Re: 2026/92259- Discharge of details reserved by condition 10 (crime prevention measures) on previous permission 2021/94363 for reserved matters application pursuant to outline permission 2018/90151 for erection of 17 dwellings at land at Yew Tree Road, Birchencliffe, Huddersfield, HD2 2EQ

Condition 10 on planning permission 2021/94363 states as follows: “Prior to the installation of any doors or windows within the hereby approved dwellings, details of measures to prevent and deter anti-social behaviour shall be submitted to and approved in writing by the Local Planning Authority. These shall include window and glazing details, doors and locking systems, CCTV and alarms and cycle and motorcycle storage.”

Drawing Title **Planning Layout**

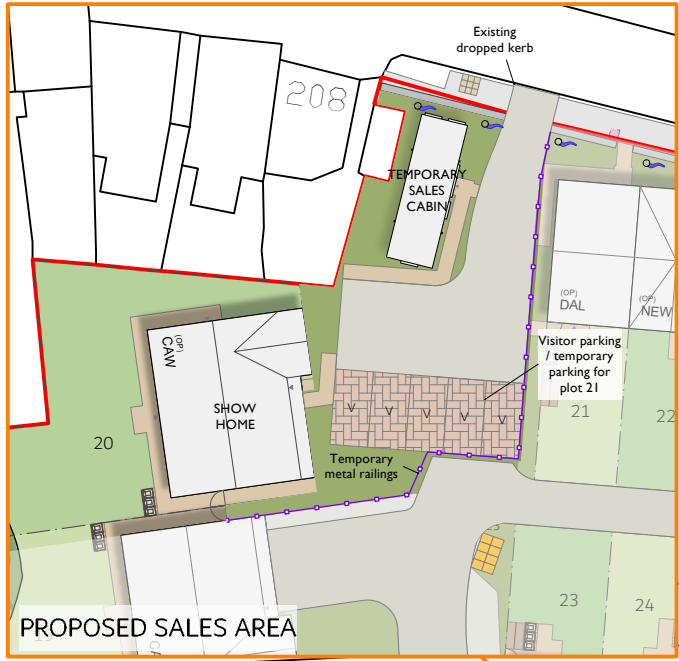
The shed for cycle/ motorcycle storage should be securely fixed to a suitable substrate foundation. Hinges should be reinforced with coach bolts. Storage devices/ ground anchors inside should be security rated to at least Sold Secure SS104 Bronze, STS 225 Issue 2 Burglar Resistance BR1(S), STS 205 Issue 8 Burglar Resistance BR1, LPS 1175 Issue 8 Security Rating A1, STS 501 Security Rating TR1 or STS 503 Security Rating TR1. Will the applicant meet some/ all of these recommendations?
